Objection to Planning Application WA/60/26/PL

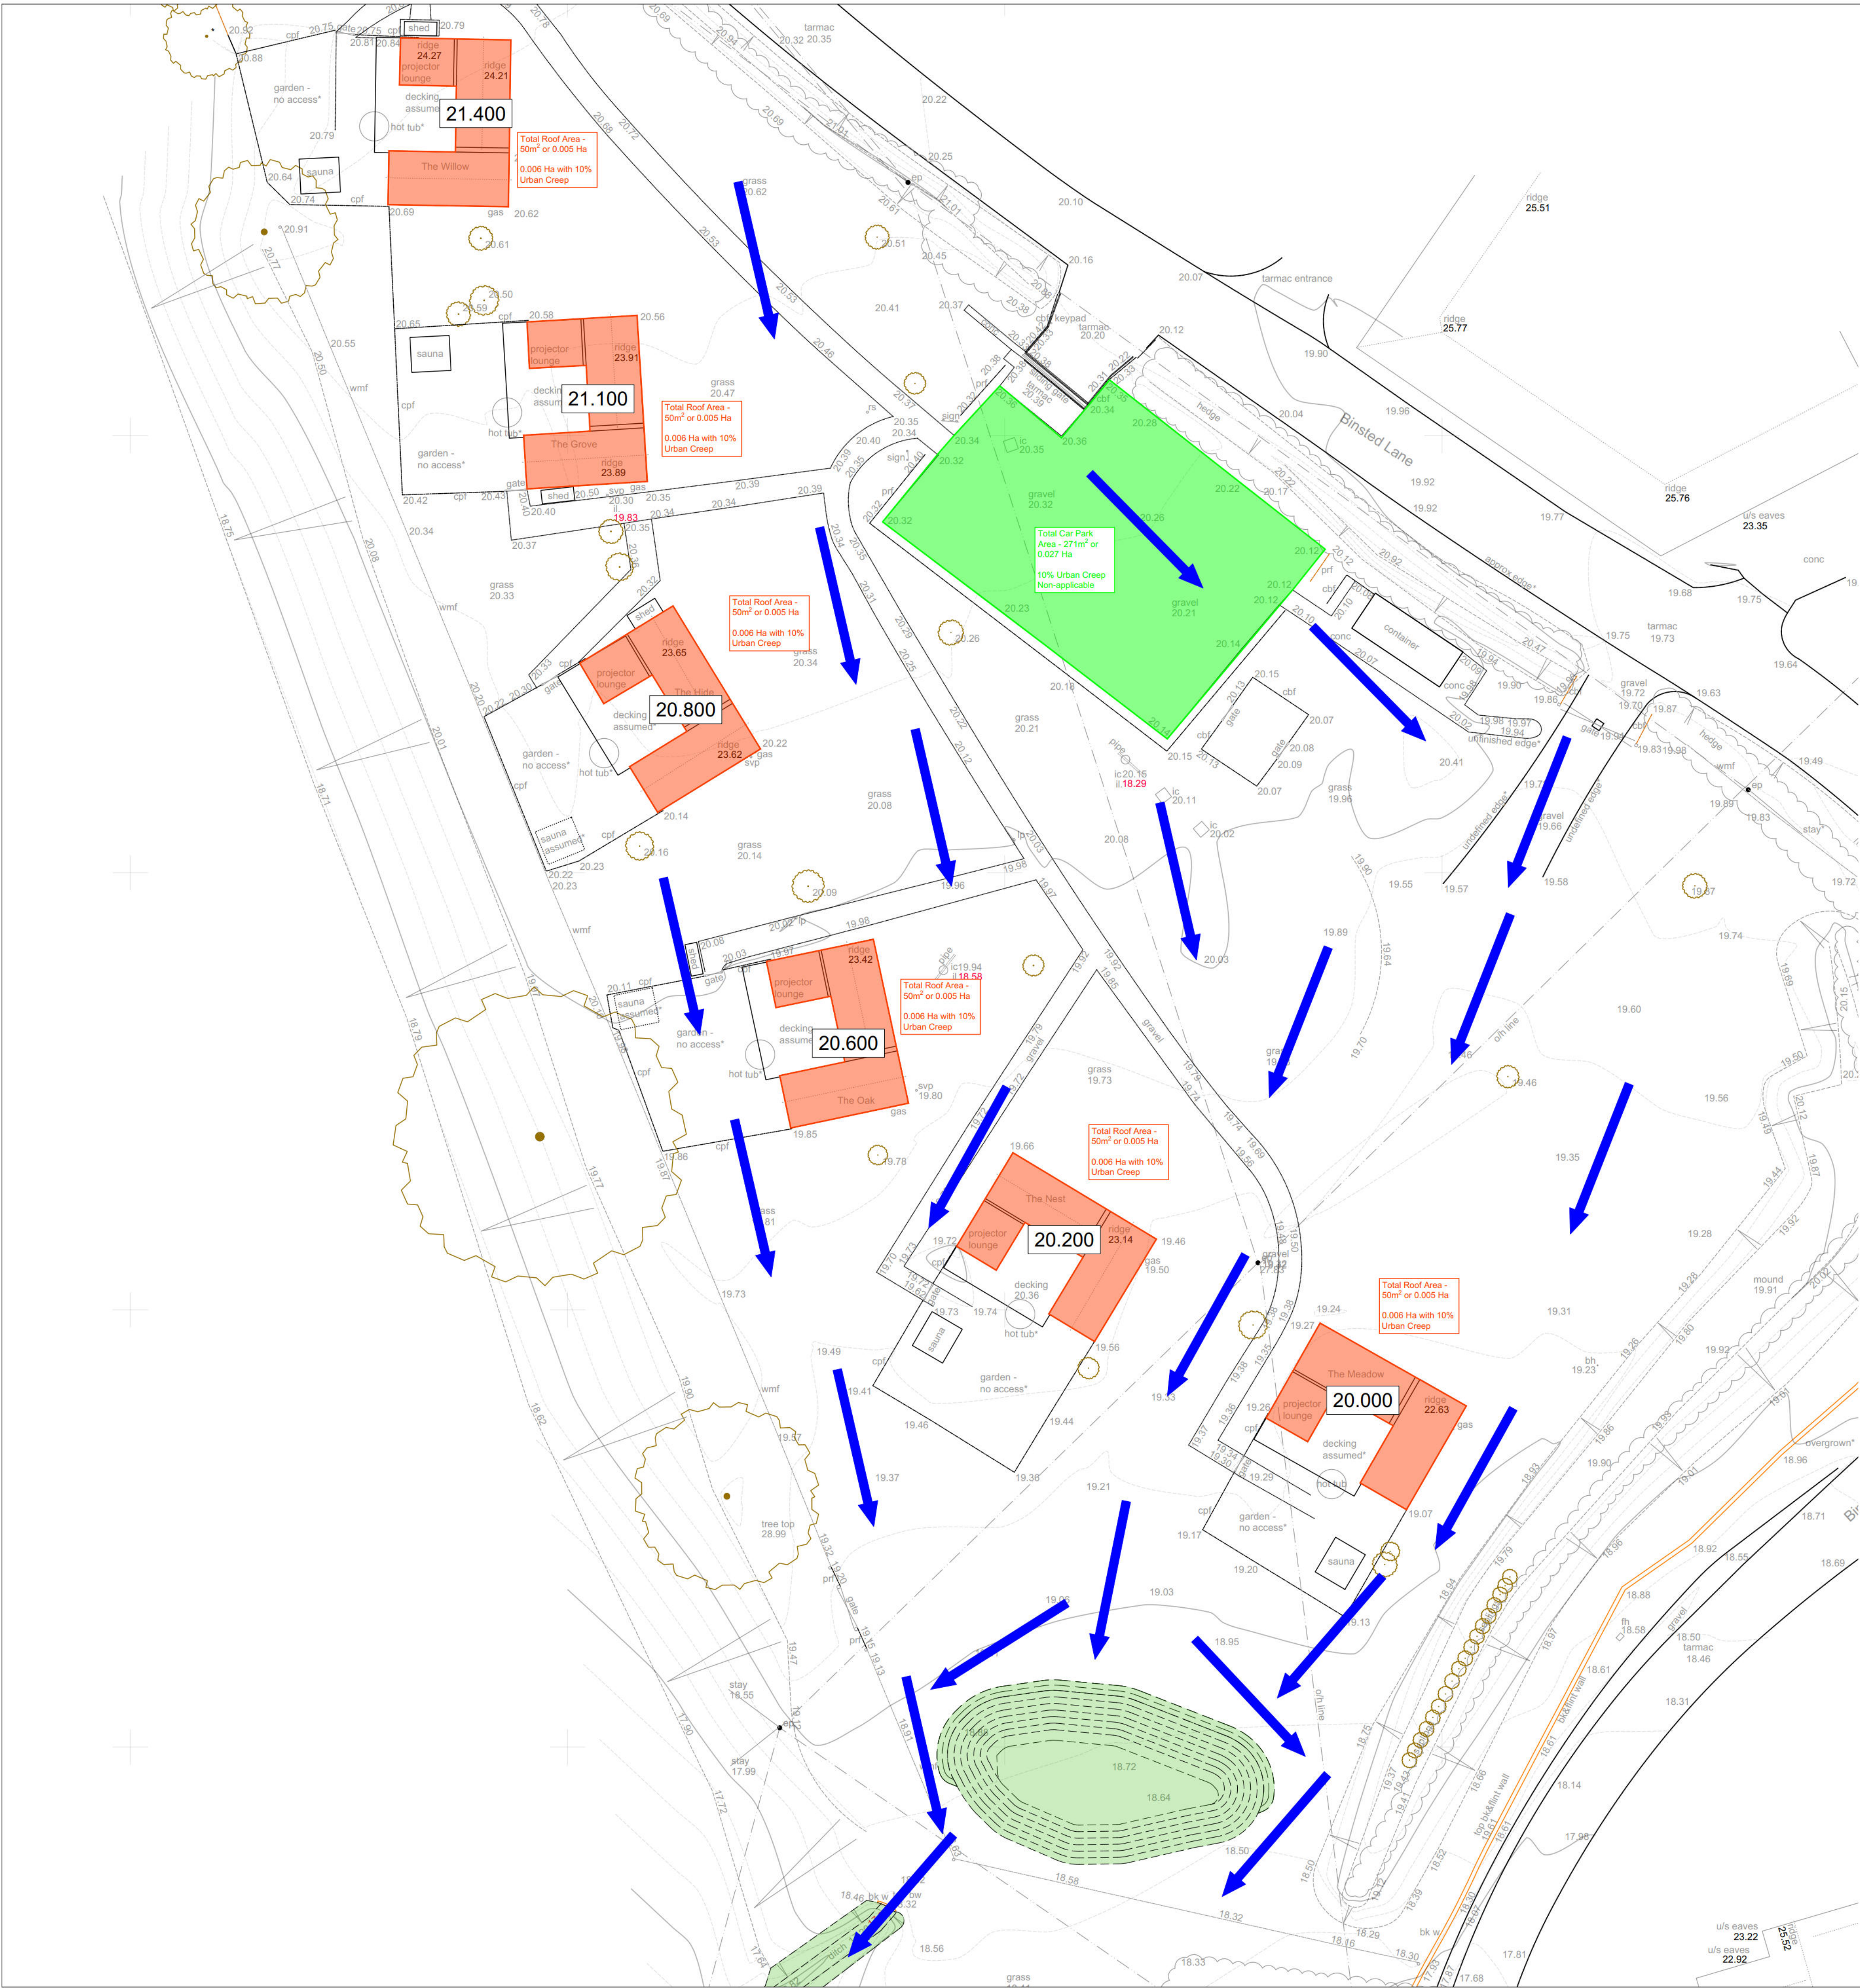
The hot tubs do not appear to have sealed collection tanks requiring wastewater to be removed from the site. Instead, wastewater is discharged via attenuation systems. Given the proximity of the sensitive chalk stream catchment, there is a significant risk that chemicals and contaminants could ultimately enter this environmentally important water system. This issue requires far greater scrutiny.

Drawing No.: 2025-6829-001	Rev.: -
----------------------------	---------

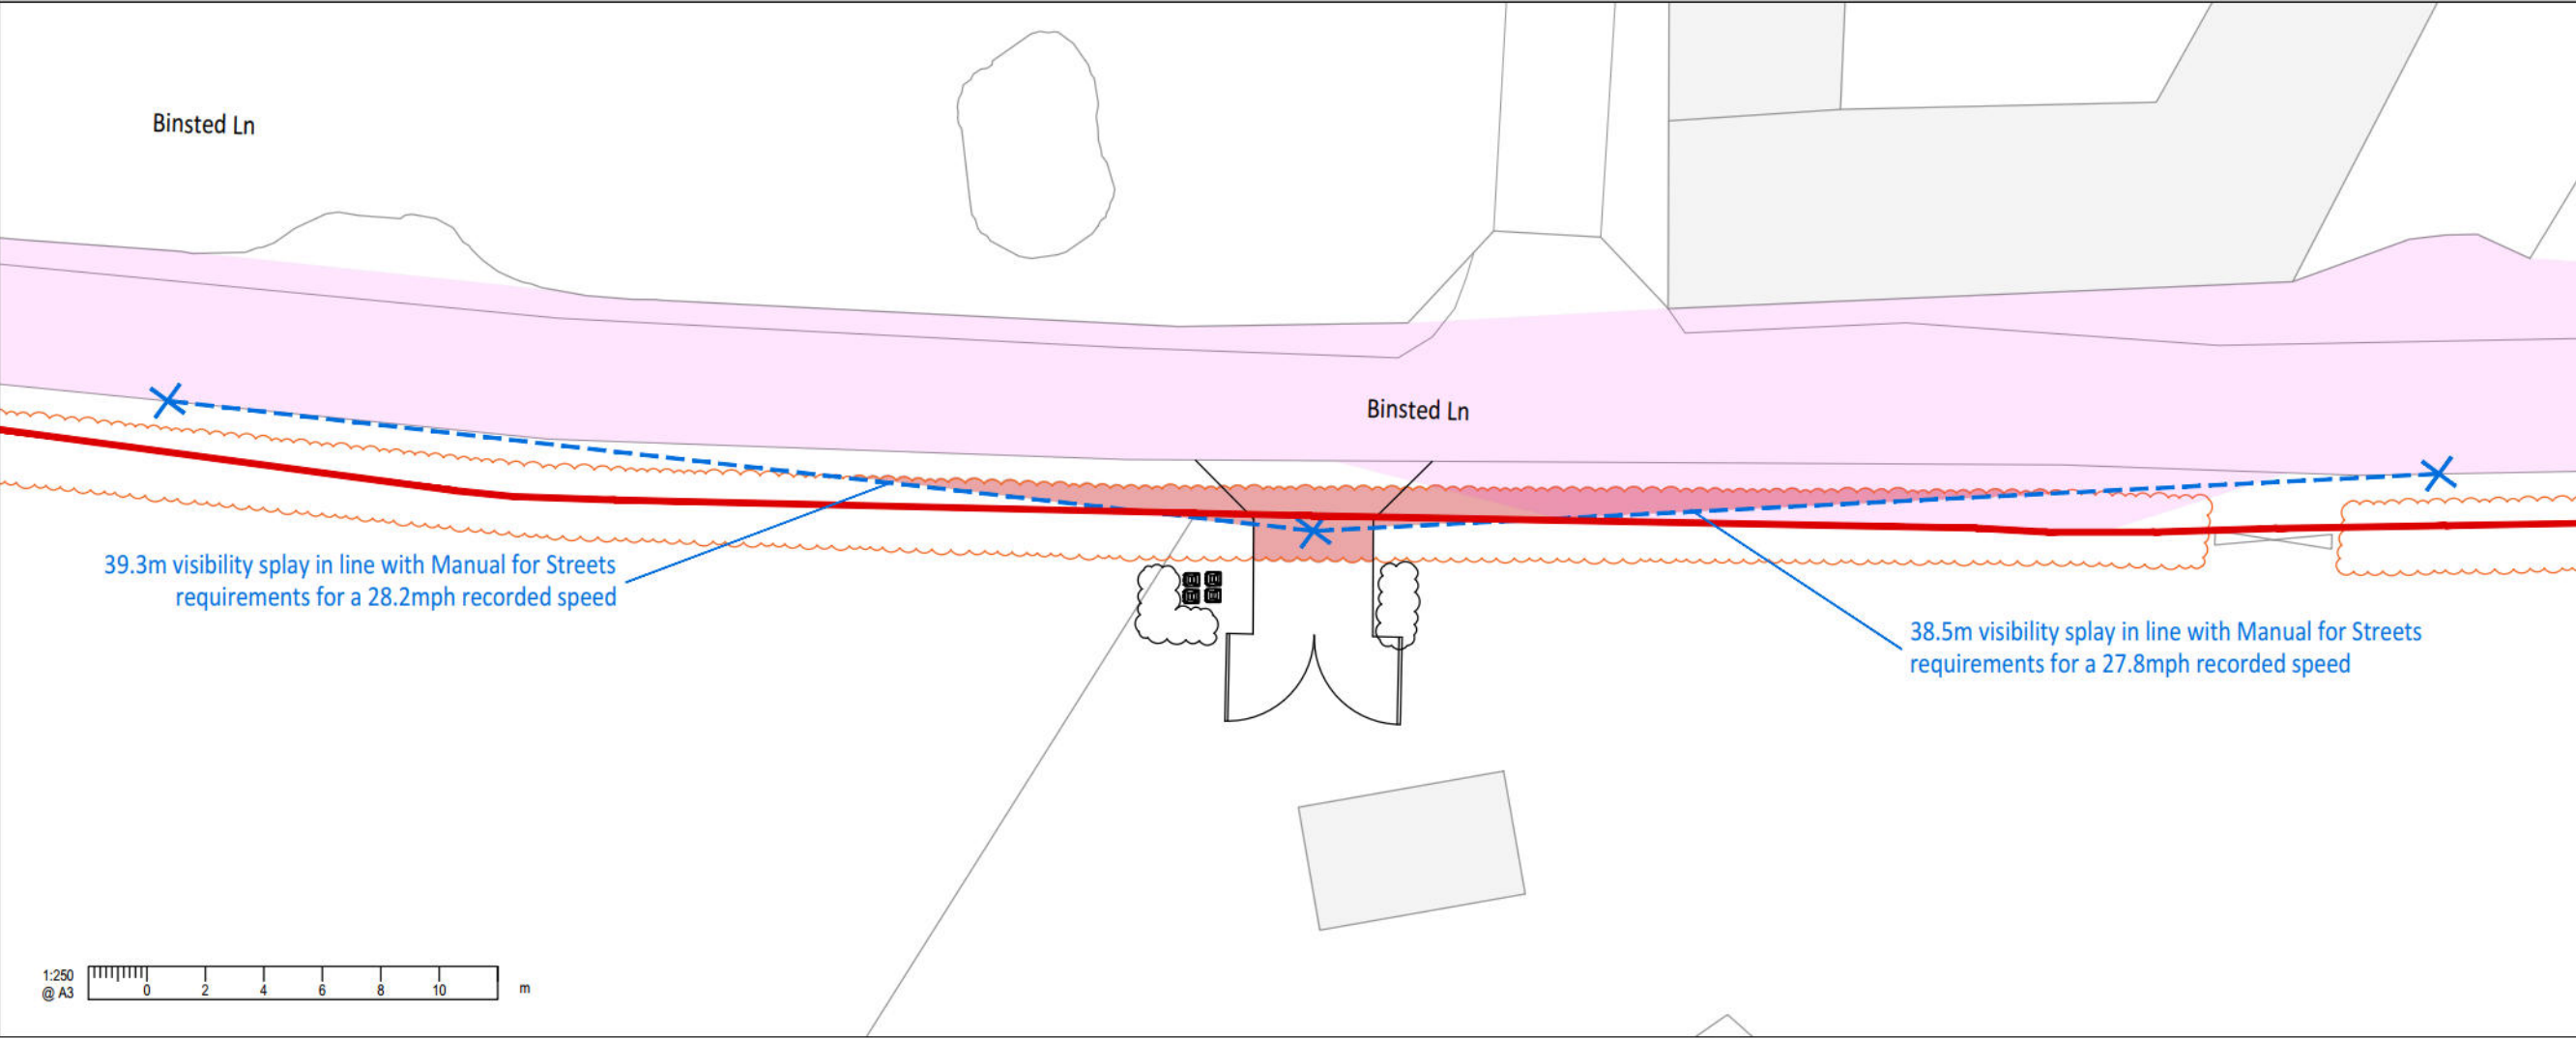
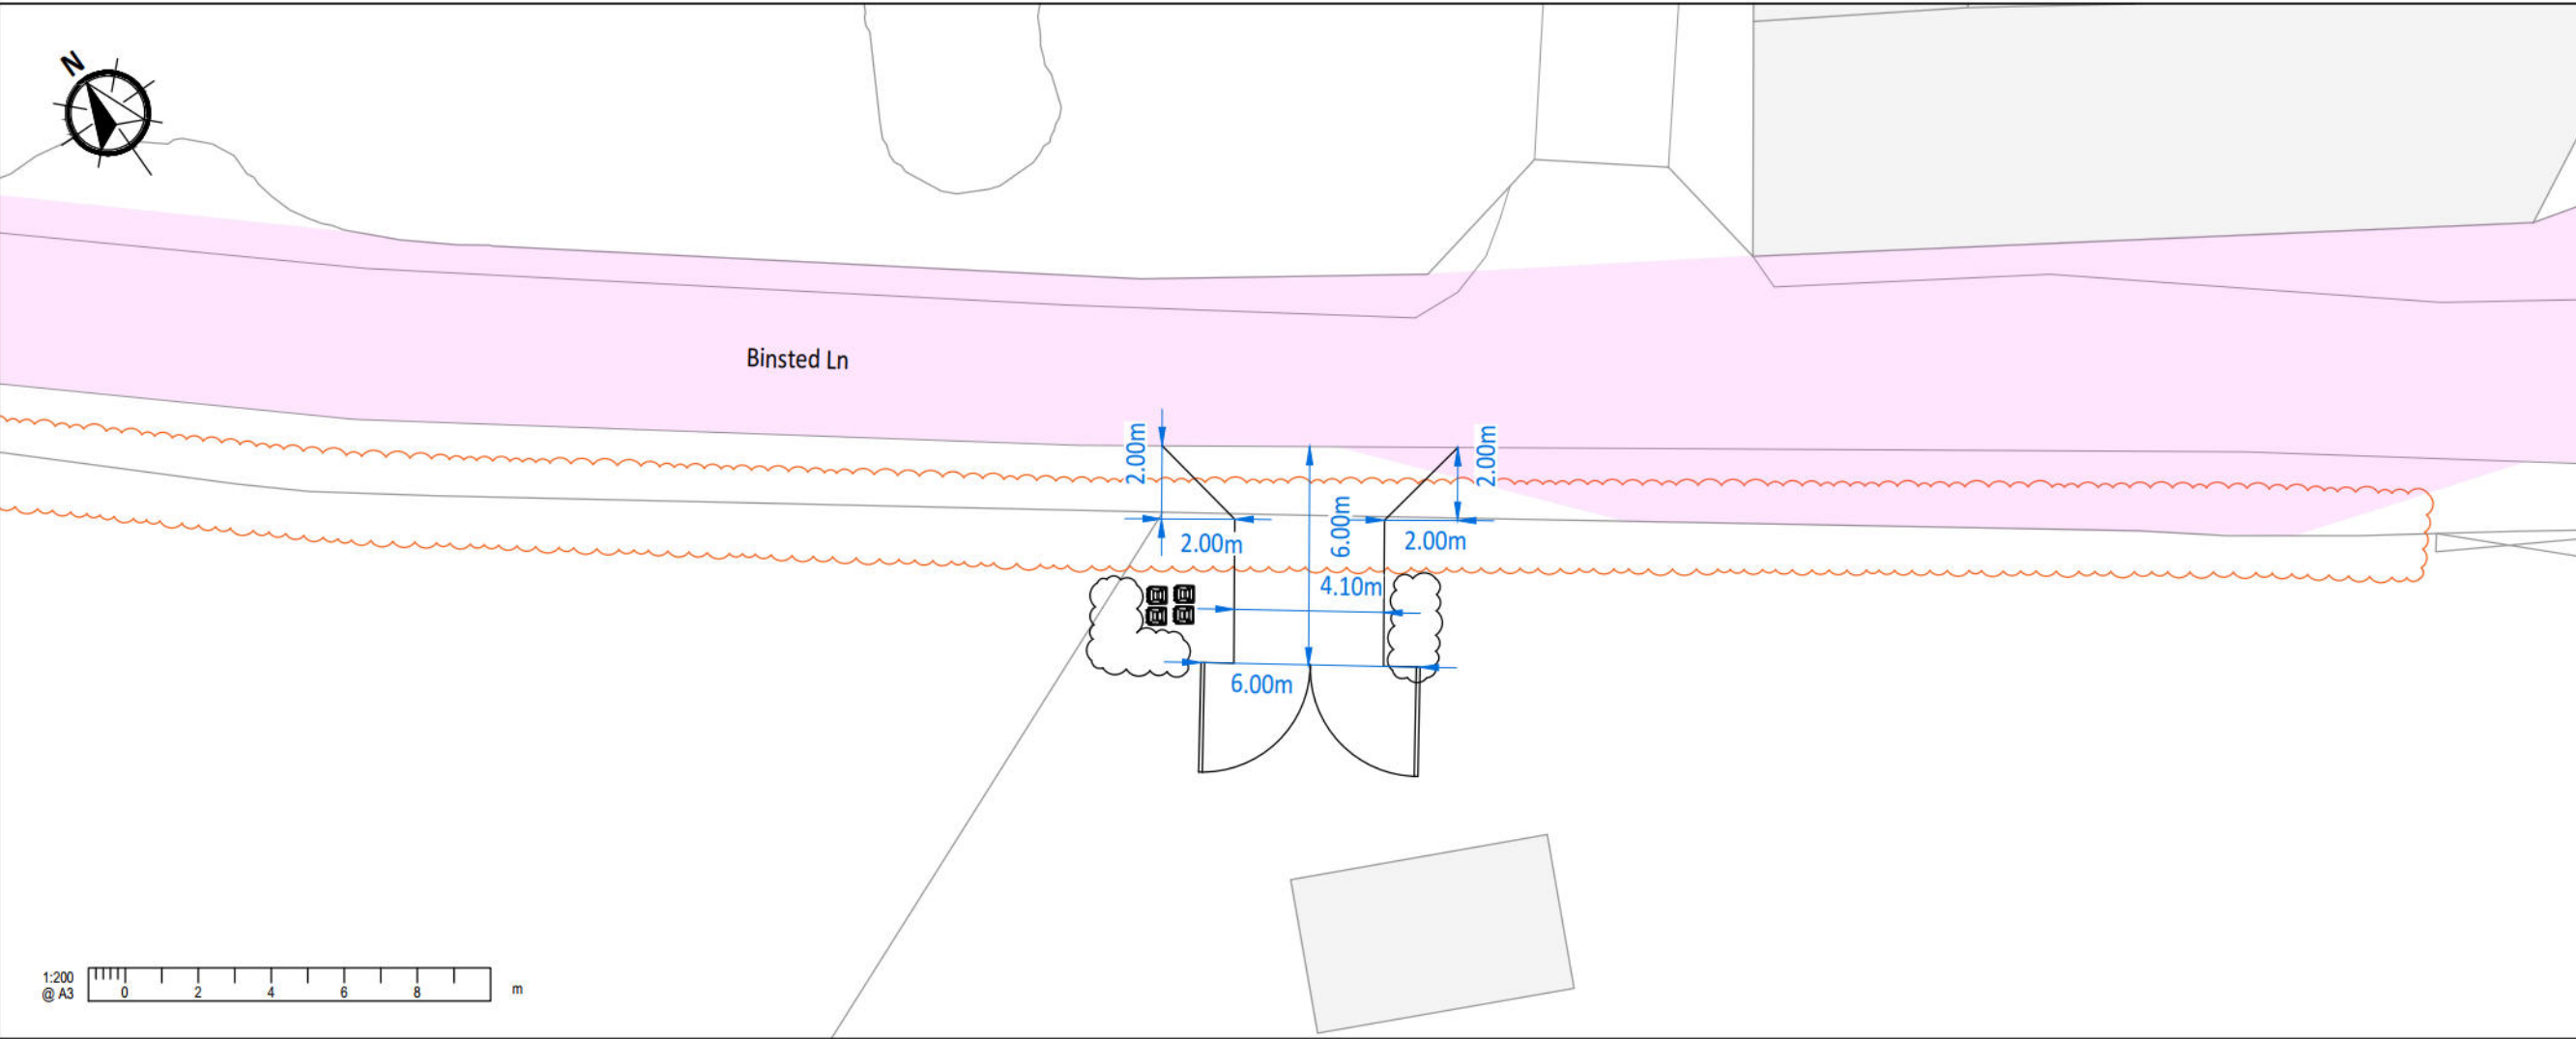
Highway safety is also a concern. The visibility splays at the site entrance should be reassessed, as vehicles exiting the site have limited visibility along the lane. In addition, taxis frequently wait on the highway outside the entrance and delivery vehicles often obstruct the road while attempting to gain access, creating further hazards.
